Subject: Comment Response
Coson Residence
7709 West Mercer Way
Mercer Island, Washington

City of Mercer Island Permit Application No. 0203-066

As requested, Associated Earth Sciences, Inc. (AESI) has prepared this comment response letter to address issues raised by the City of Mercer Island in a letter dated January 28, 2005. Listed below are the responses to the geotechnical-related correction items. The numbering of the listed items corresponds to the number sequence in the January 28, 2005 letter.

FIGURE 3

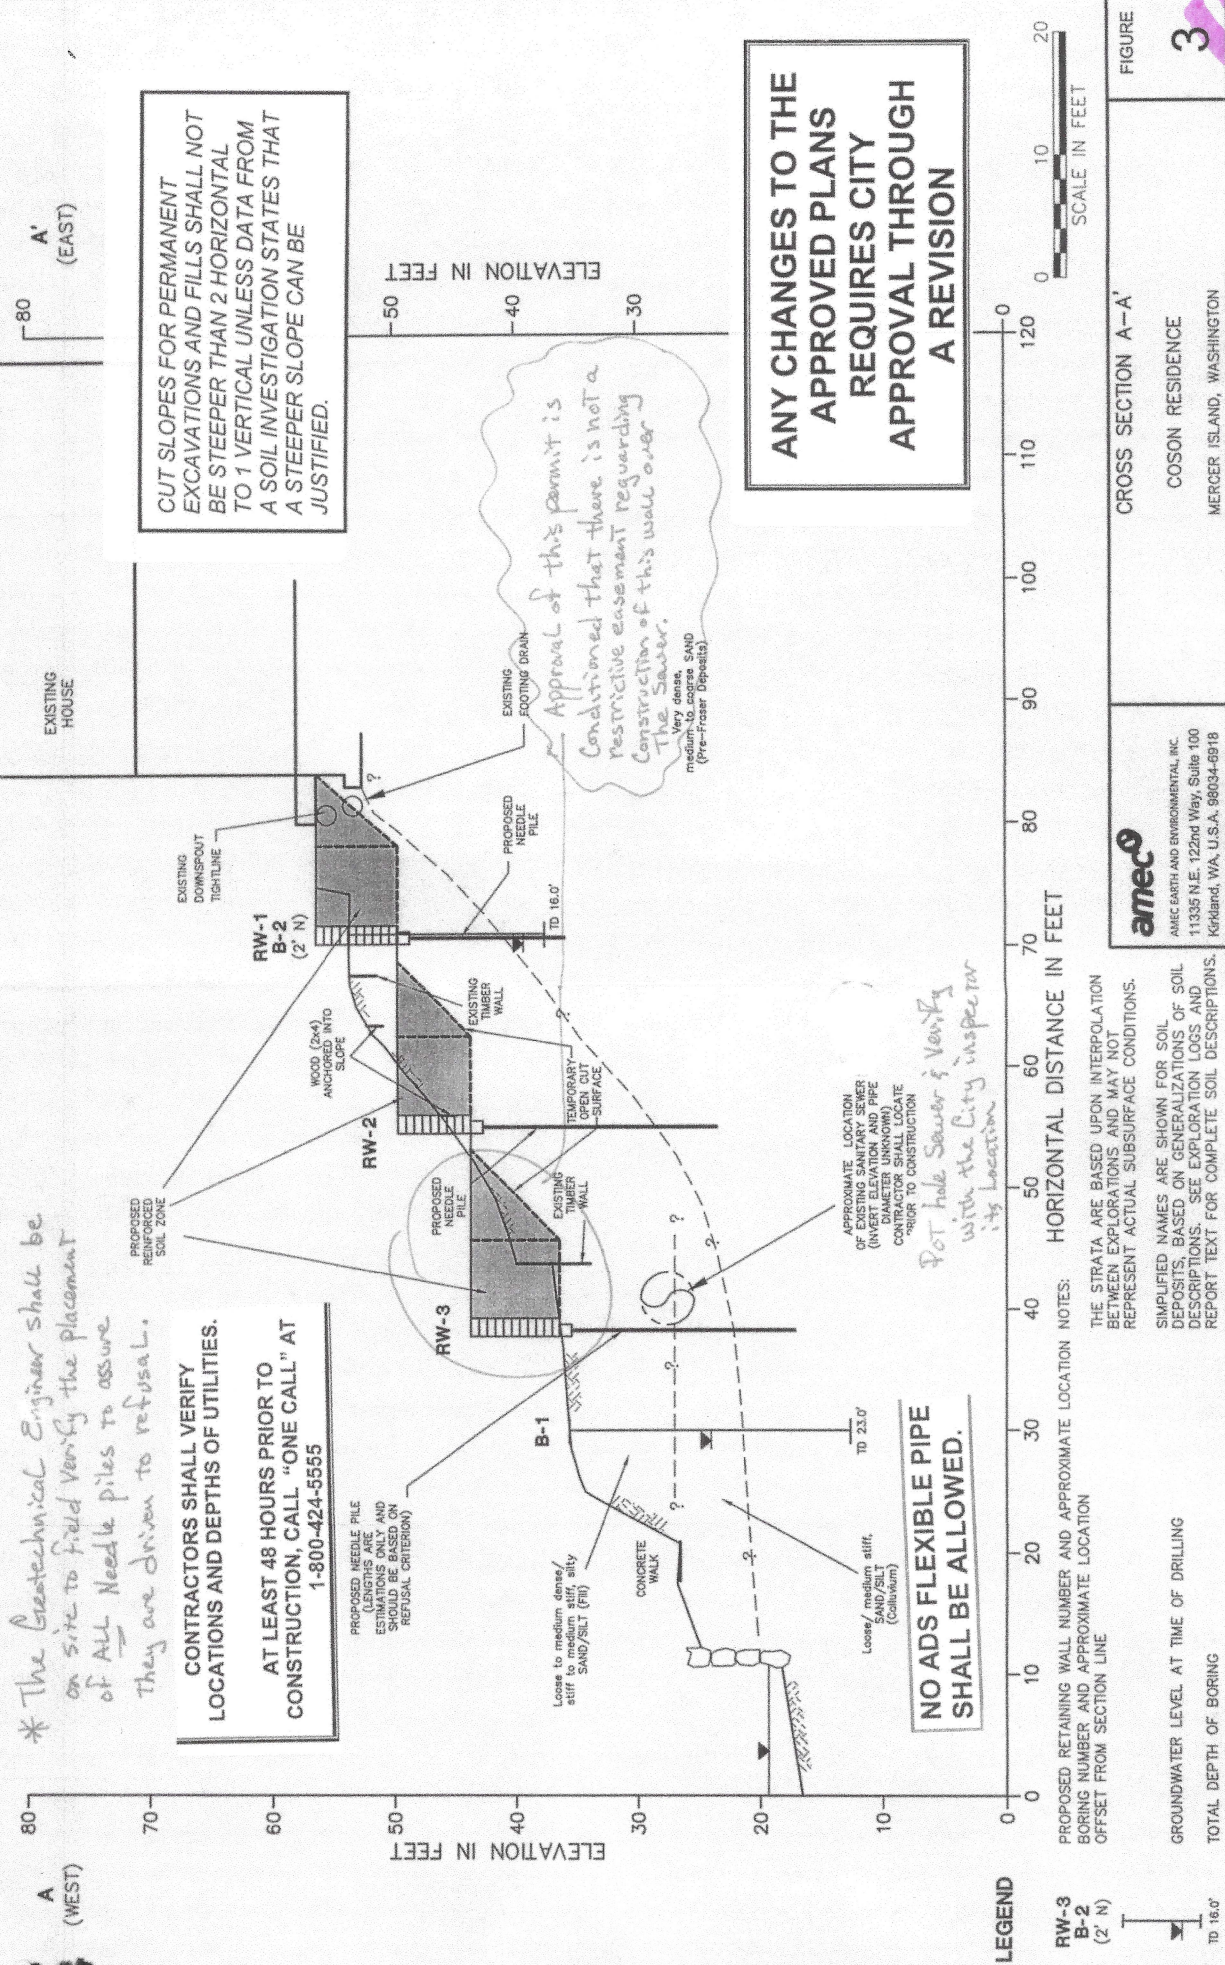
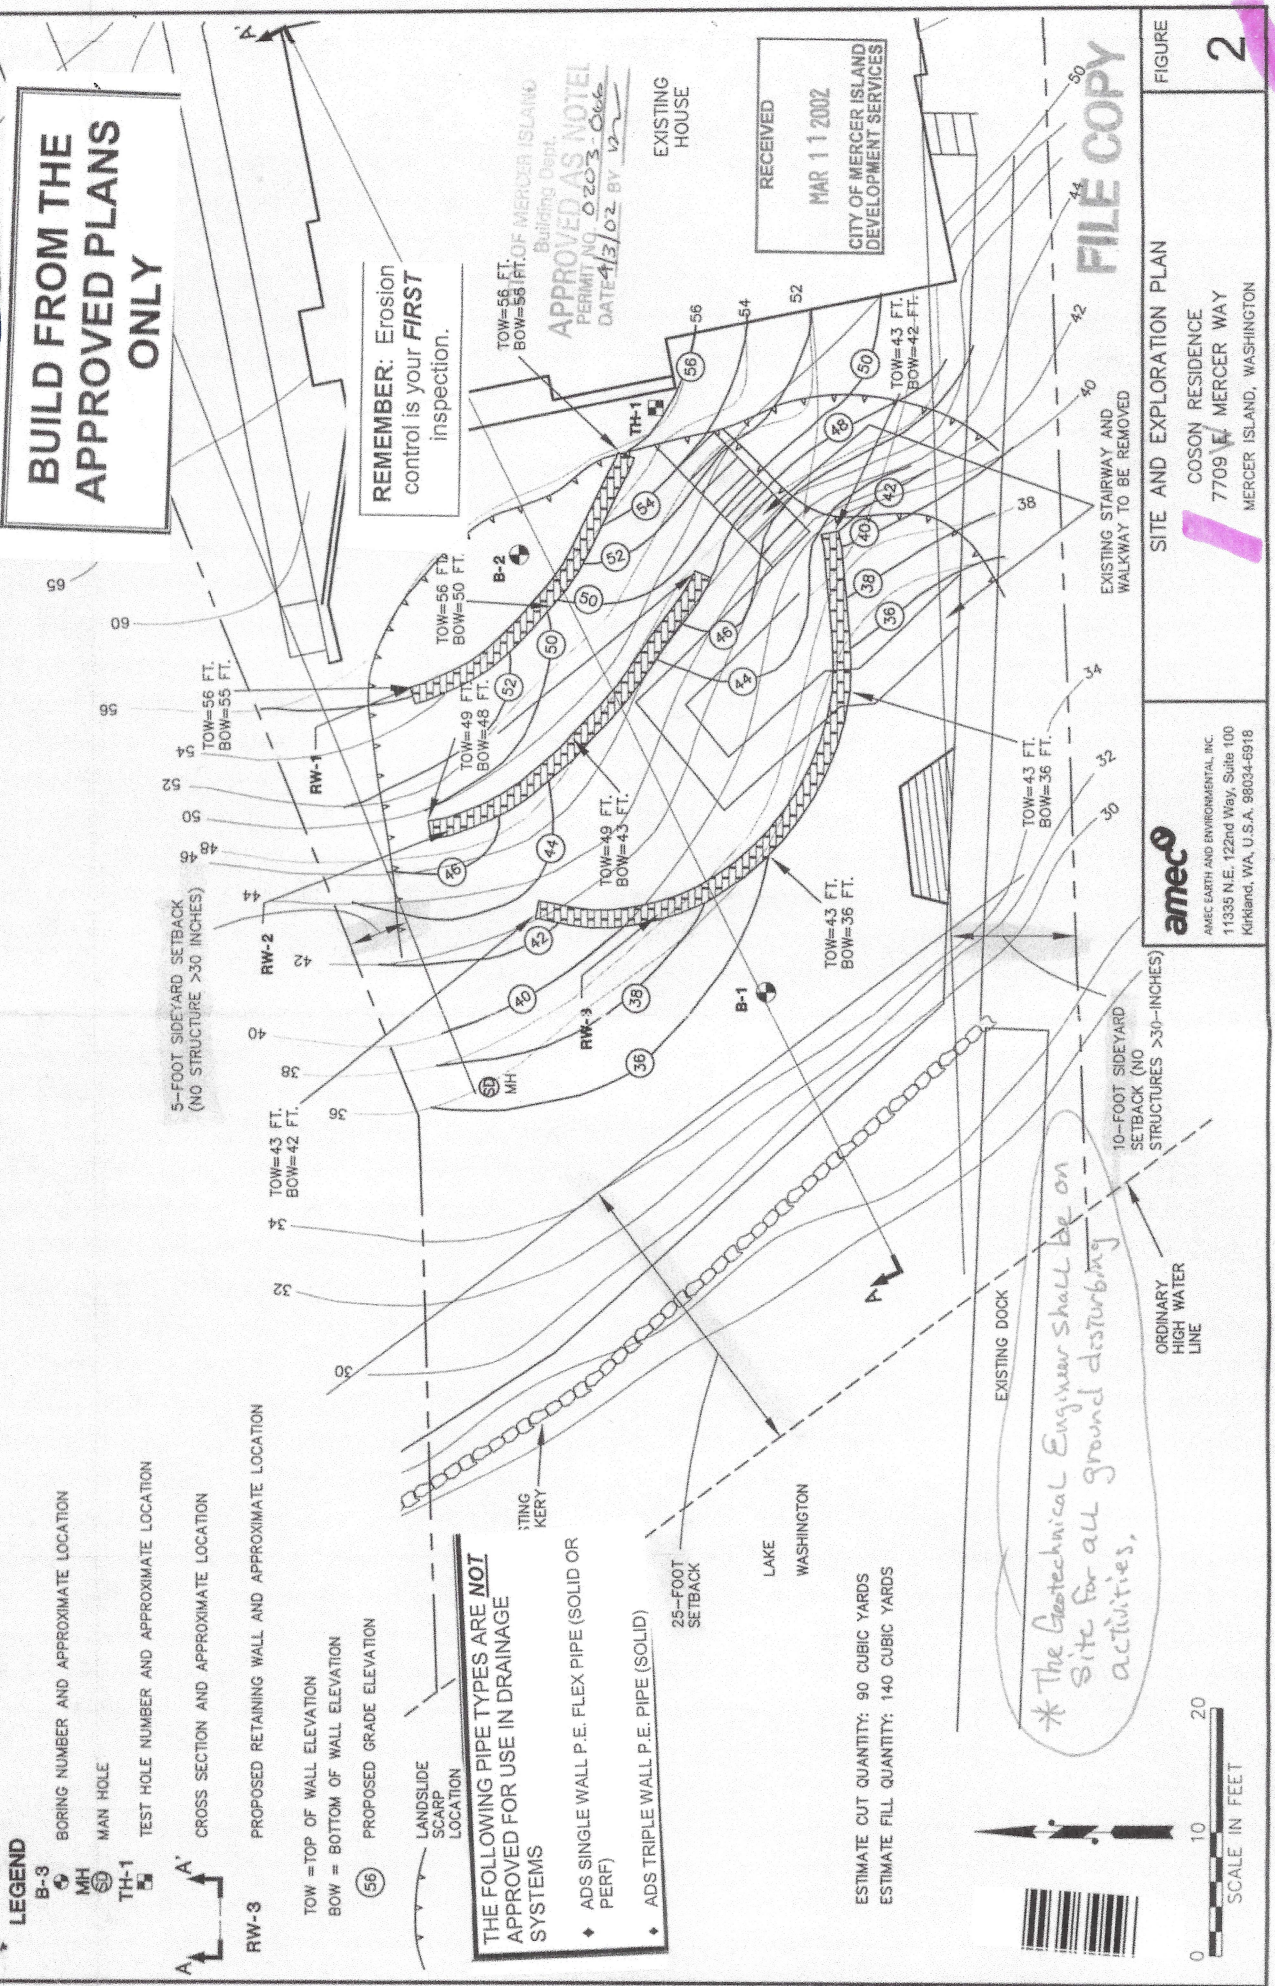
AMEC Earth & Environmental, Inc. (AMEC) completed a slope stability assessment and segmental block wall design report for this site dated January 14, 2002. The report was prepared in response to a slide that occurred on the western (rear) side of the existing home. It was reported that the slide occurred in the spring of 2001 as the result of a broken water line. The January 2002 report states that the owner wanted a terraced backyard and thus, the AMEC report focus was on a tiered wall system.

AMEC completed slope stability analyses that evaluated the site under the current conditions (post-slide without any repair work) and under the proposed conditions (a three-wall terraced backyard). Table 2 on page 9 of the AMEC report provides a summary of the safety factors associated with static conditions. As summarized in this table, there would be no improvement to the static factor of safety with the proposed walls (1.17 factor of safety). The AMEC report states that the factor of safety under seismic conditions is less than 1.0 in all analyzed scenarios (indicating incipient failure). Further, the AMEC report states (page 8) that "while a higher static and seismic factor of safety would be desirable, the construction cost to achieve this is very high in relation to the value of the property and the end use of the backyard area."

The concrete facing units for the tiered walls proposed by AMEC were to be supported on a pipe-pile-supported grade beam. This is generally not considered advisable due to the potential differential settlement between the concrete facing units and the geogrid-reinforced soil mass. The reinforced soil mass is an integral part of the wall system. Differential settlement between the two elements (soil reinforcement and concrete facing) could result in a wall that does not perform as intended.

Multiple walls on a site do not increase the stability over that achieved by a single wall. In fact, it is generally recommended that tiered systems be avoided due to surcharge loading effects.

Similar to the walls proposed by AMEC, the Geoweb® wall proposed by AESI (letter dated June 23, 2003) and constructed by Waterfront Construction in the spring of 2004 is not designed to significantly improve the global stability of the property. The Geoweb® wall will stabilize the landscape area and help to prevent additional erosion and sediment transport from the yard into Lake Washington. This Geoweb® wall should provide the same level of site stability as the tiered system proposed by AMEC.

Since the work was permitted based on AMEC's January 14, 2002 report and AESI's recommended Geoweb® wall would provide a similar factor of safety for slope stability, it is our opinion that the revision to the permit using the Geoweb® system is not materially different from the originally permitted wall.

A copy of the sewer easement is attached. To our knowledge, the sewer line was approximately located on the original permit drawings by AMEC in the vicinity below (west of) the Geoweb® wall. While the original permitted AMEC wall was shown located over the sewer line (with pipe piling driven immediately next to the line) the Geoweb® wall is located farther east away from this location. The Geoweb® wall replaced the timber wall that was destroyed by the slide and does not encroach closer to the sewer line.
